NW Bicester Eco Development

Transport Assessment: Addendum – 5th April 2011

Figure 5.4

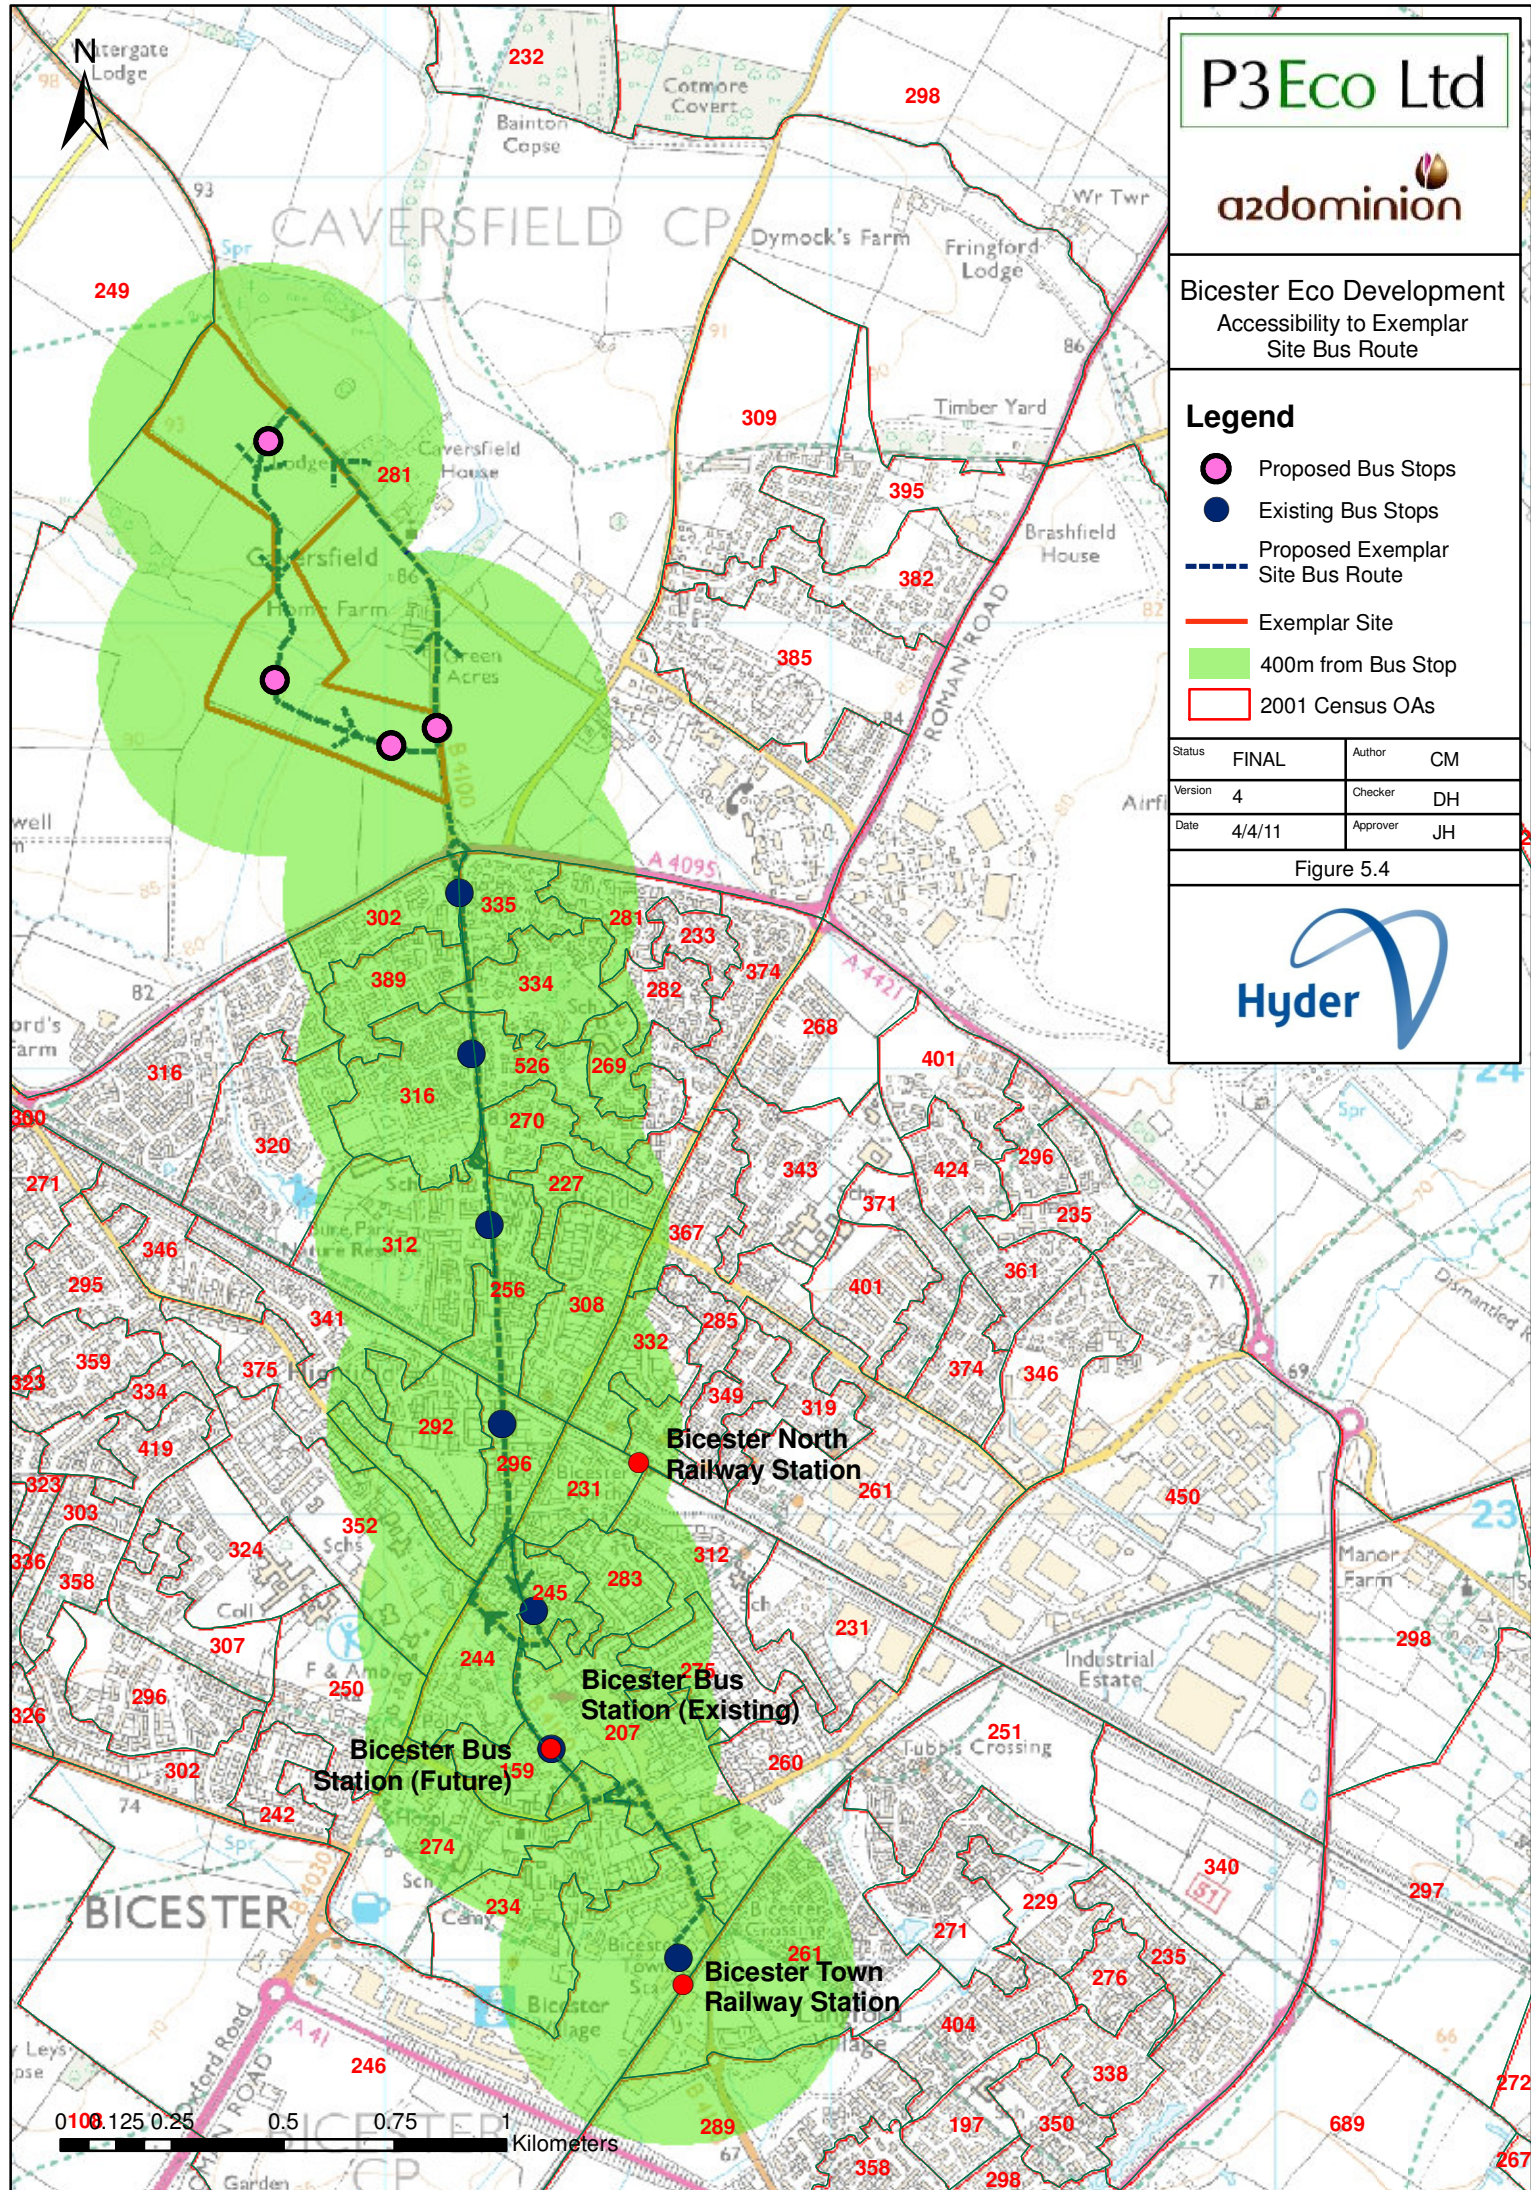
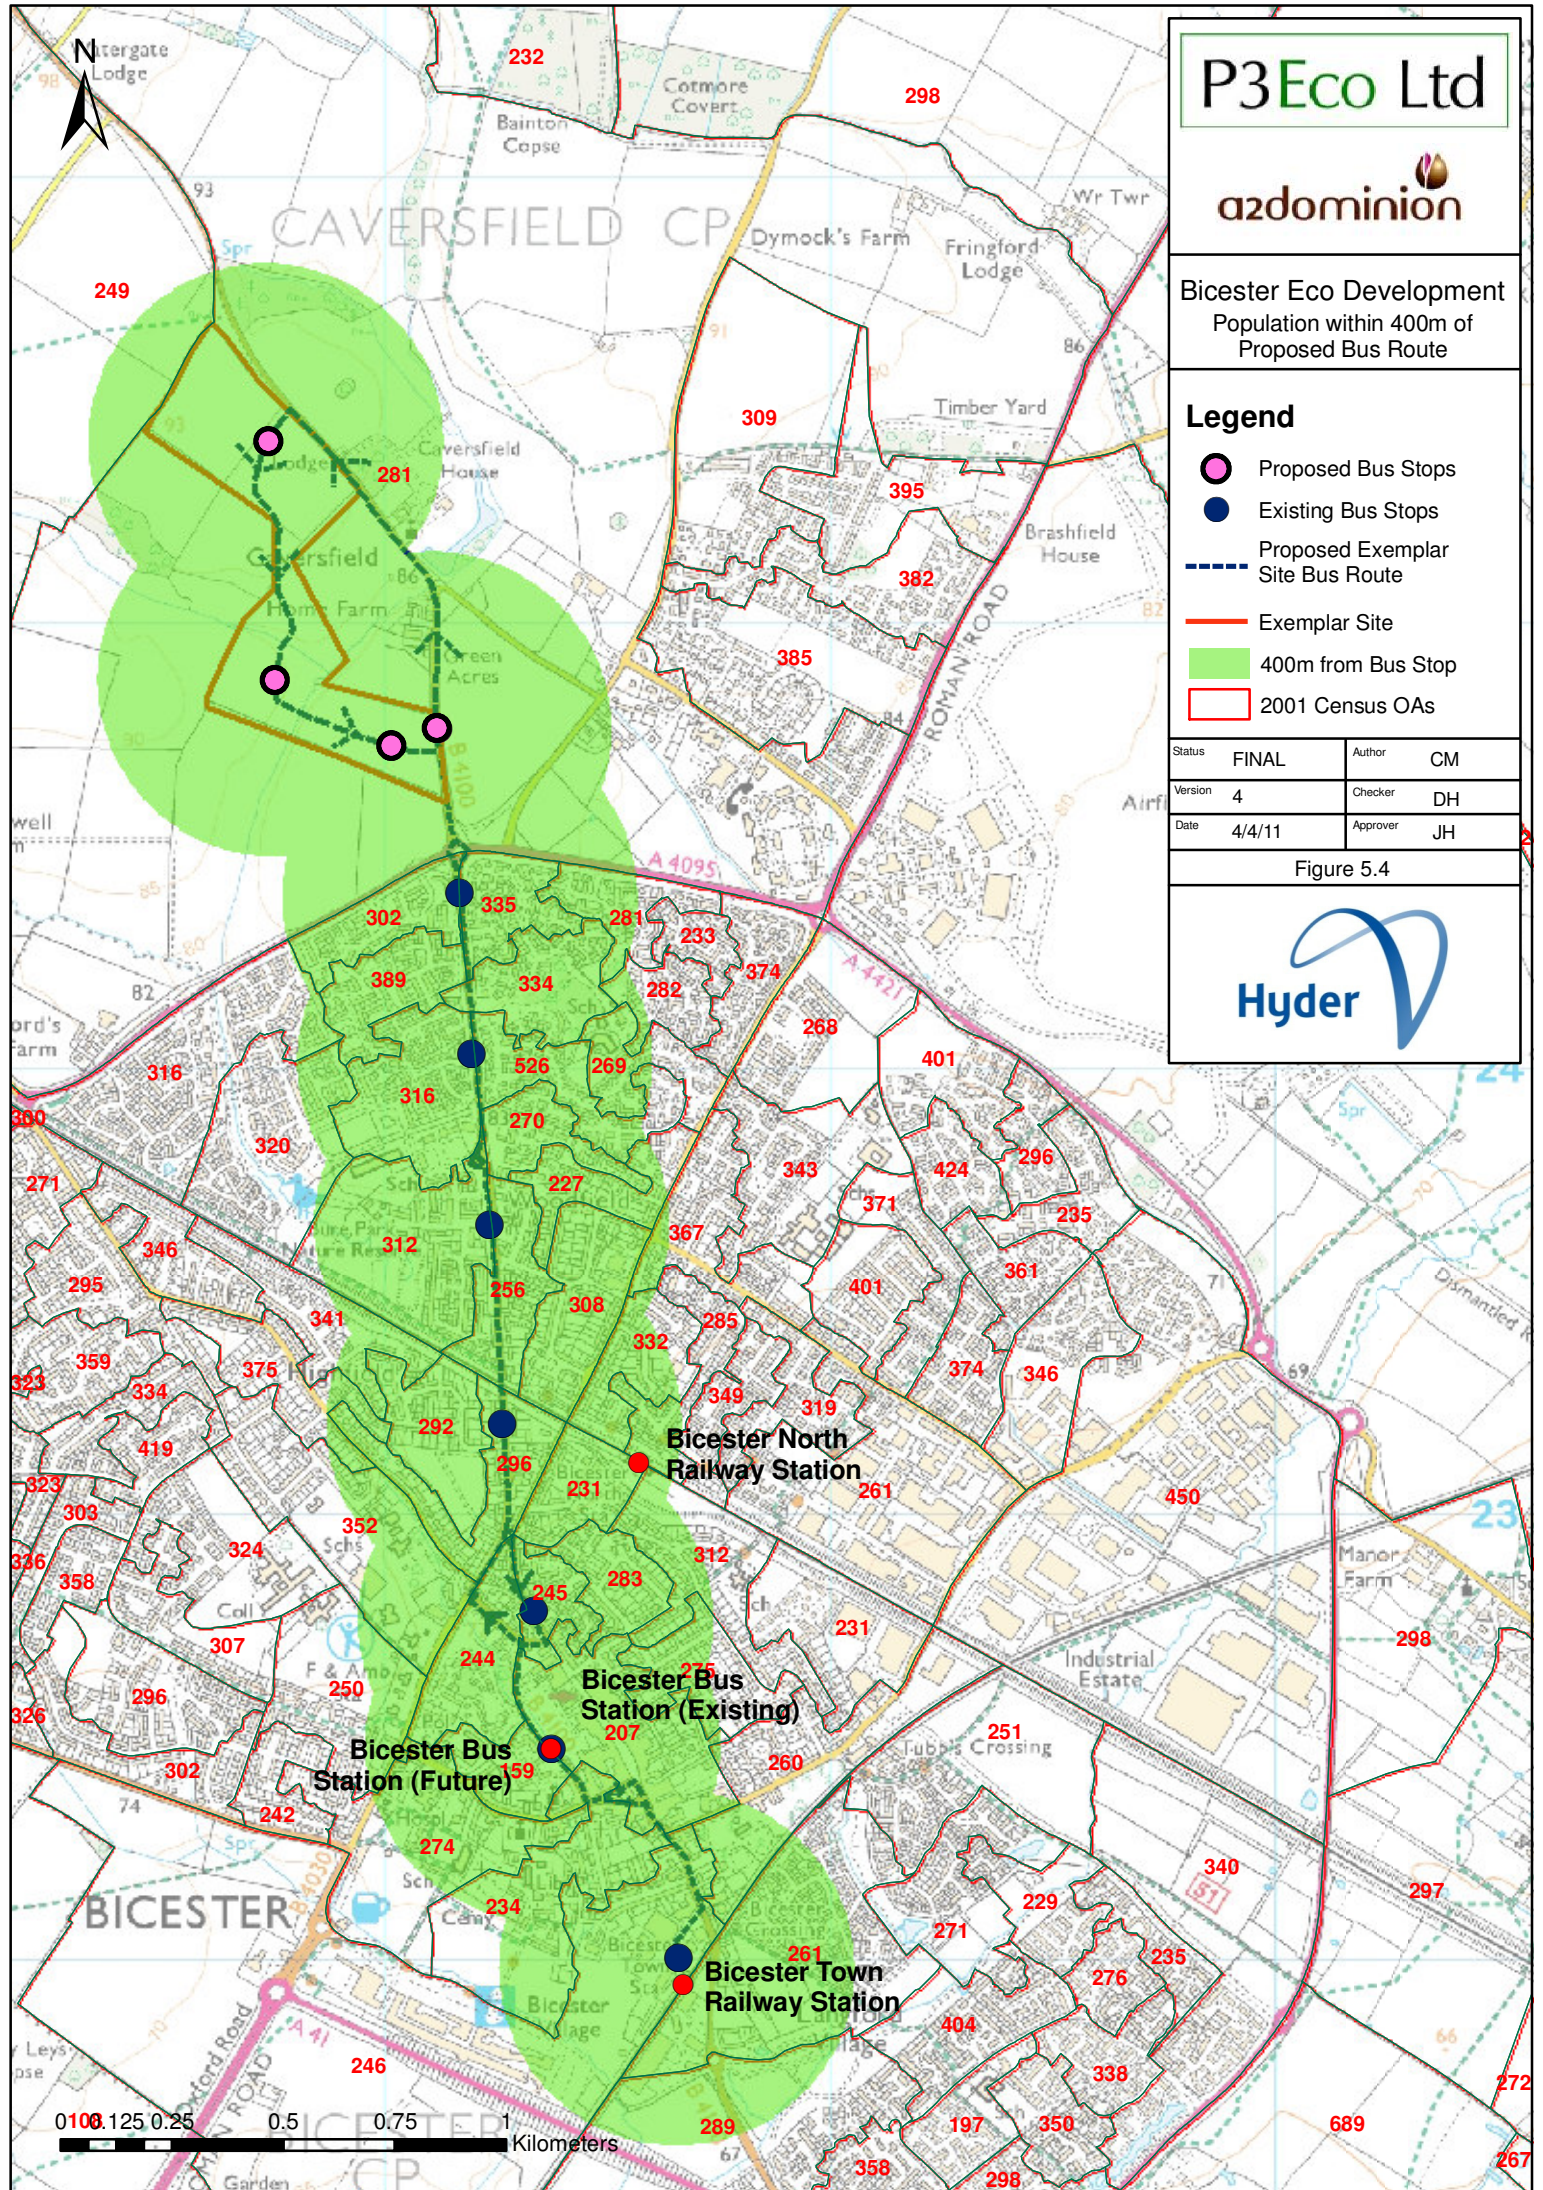
The bus route will not only serve the development site, but provide a new bus service for residents in the Banbury Road area of Bicester. The population of the town living within 400m walking distance of a proposed bus stop is shown in **Figure 5.4**, and is estimated as some 11,000 people. These residents will benefit from the 15 minute frequency service which connects to the rail stations and the town centre.

Bicester Eco Development
Transport Proposals Plan

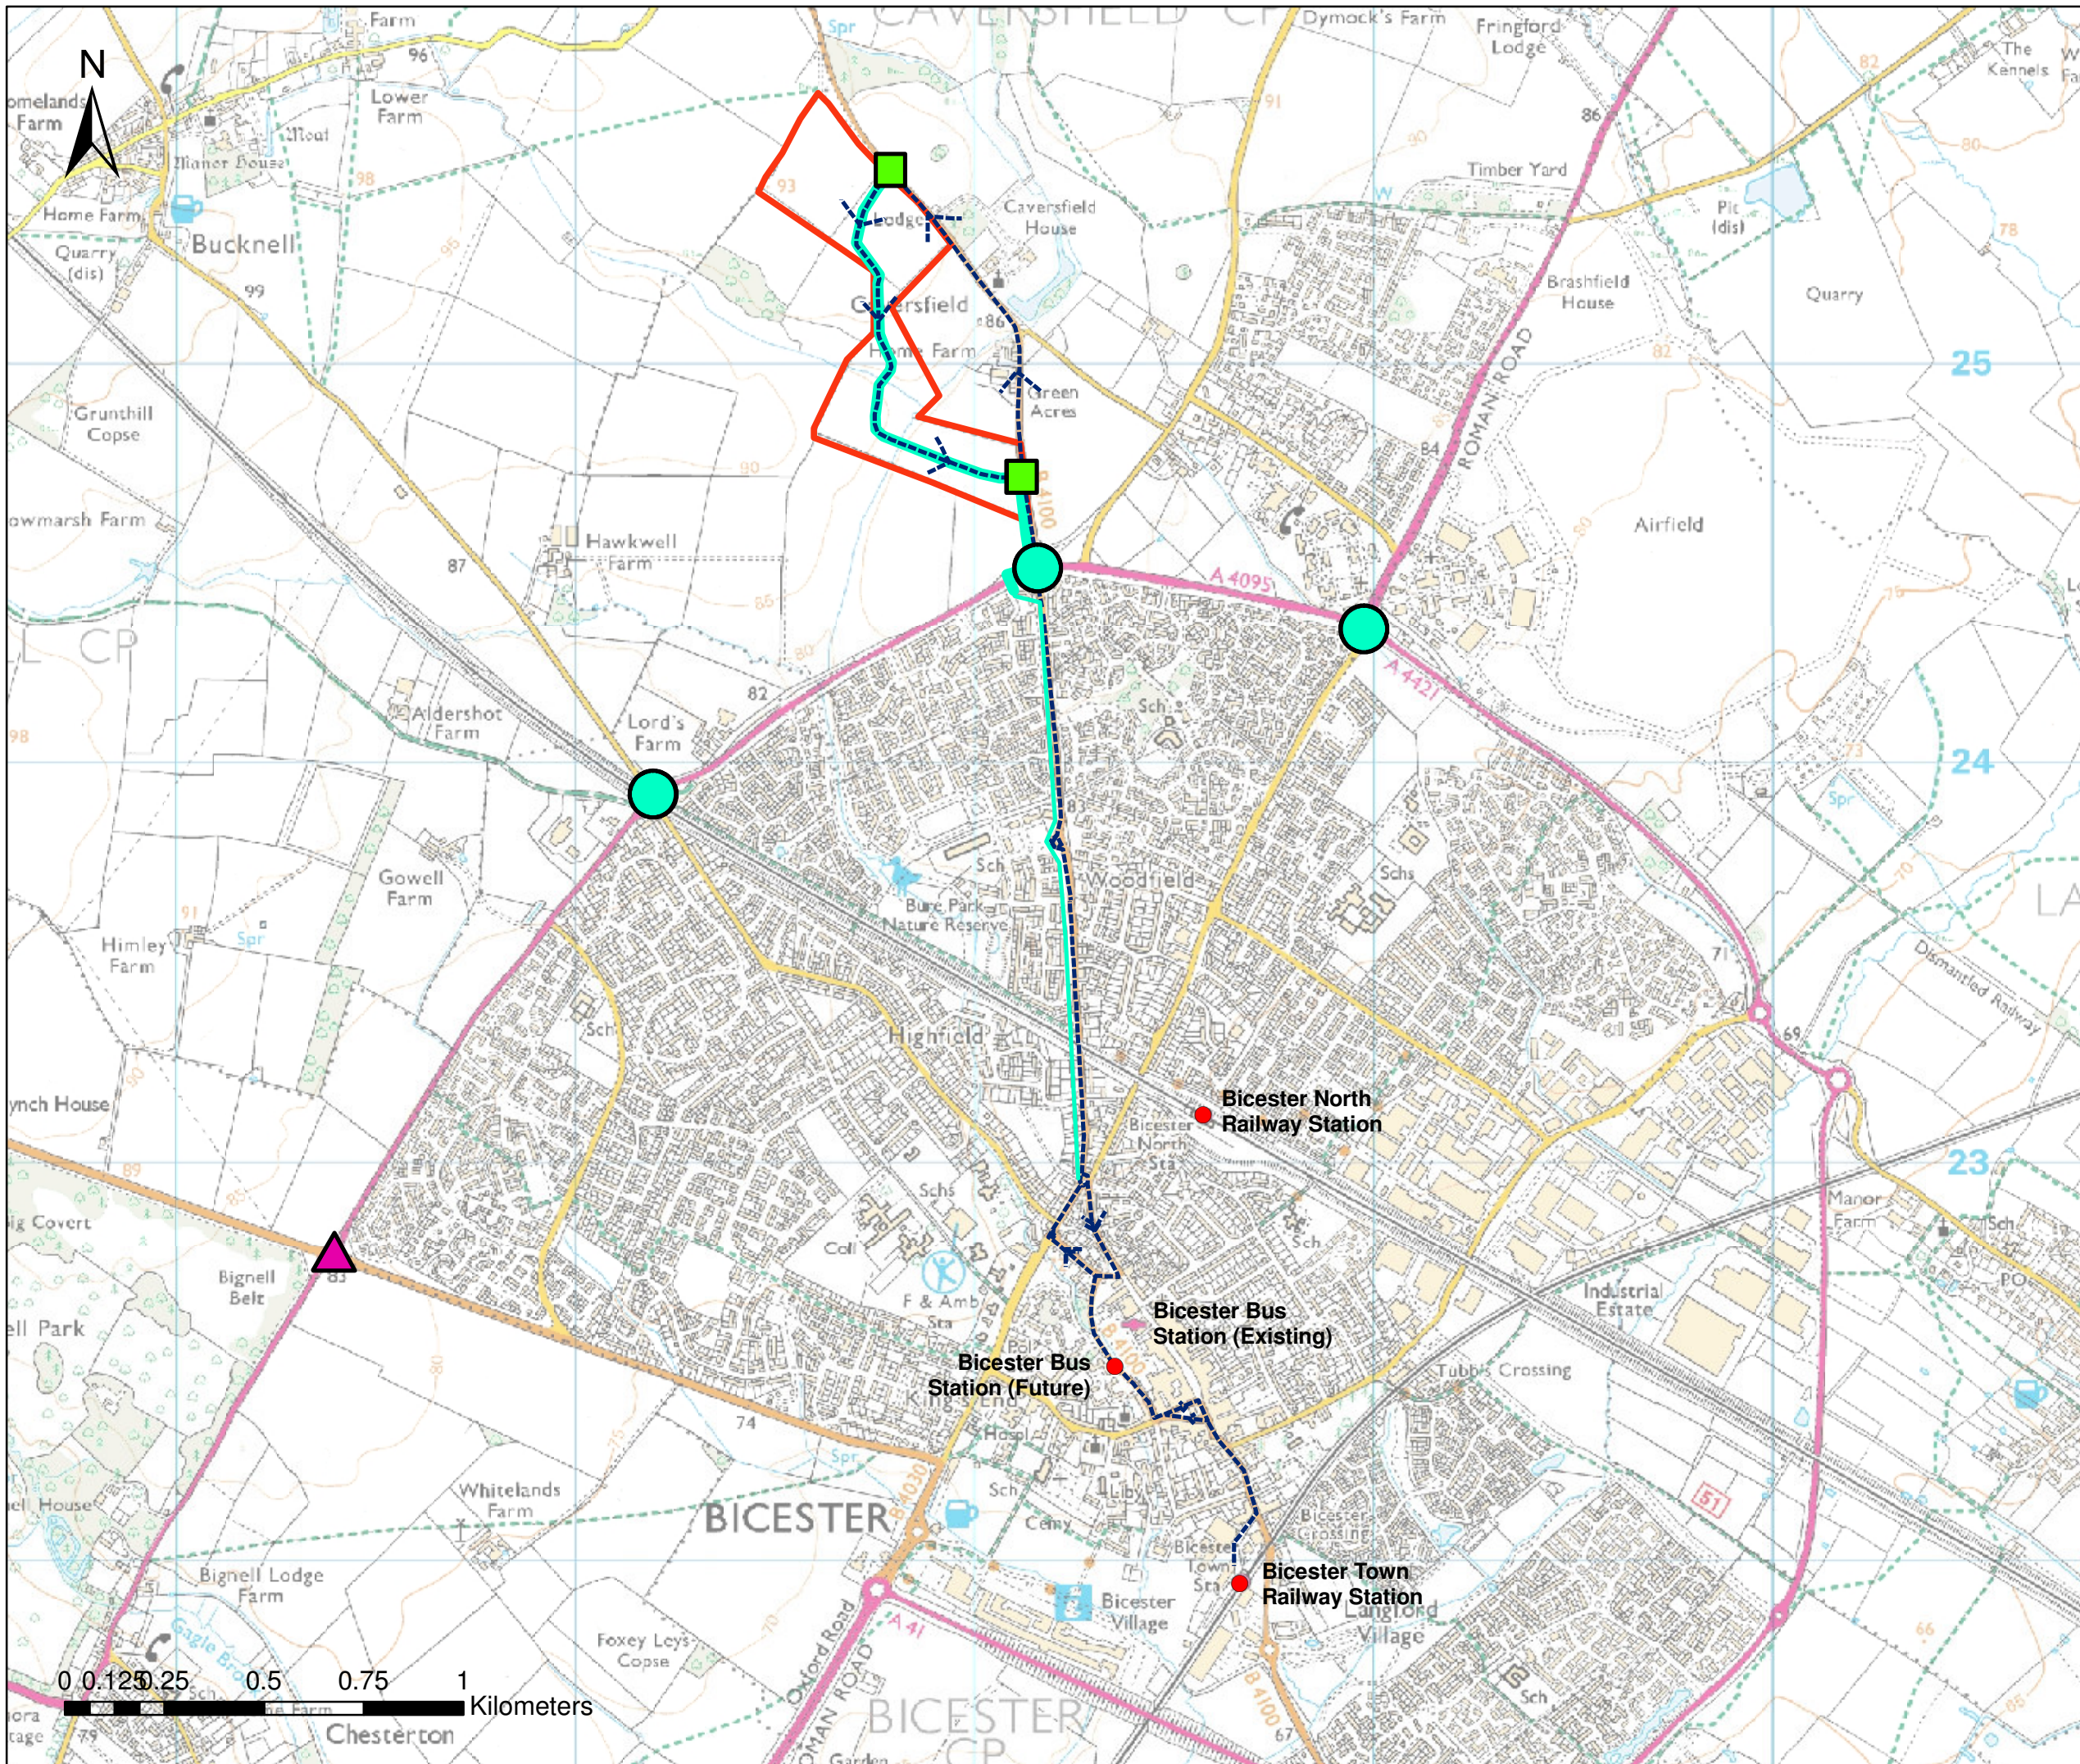
The two parts of the site will be linked by a bus, cycle, taxi, emergency and refuse vehicle only link. This will discourage residents in the northern part of the site from making very short journeys by car to the shops and services in the southern part. This will mean that the northern access from Banbury Road will serve 227 residential properties and the southern access will serve 166 residential properties and the non-residential uses.
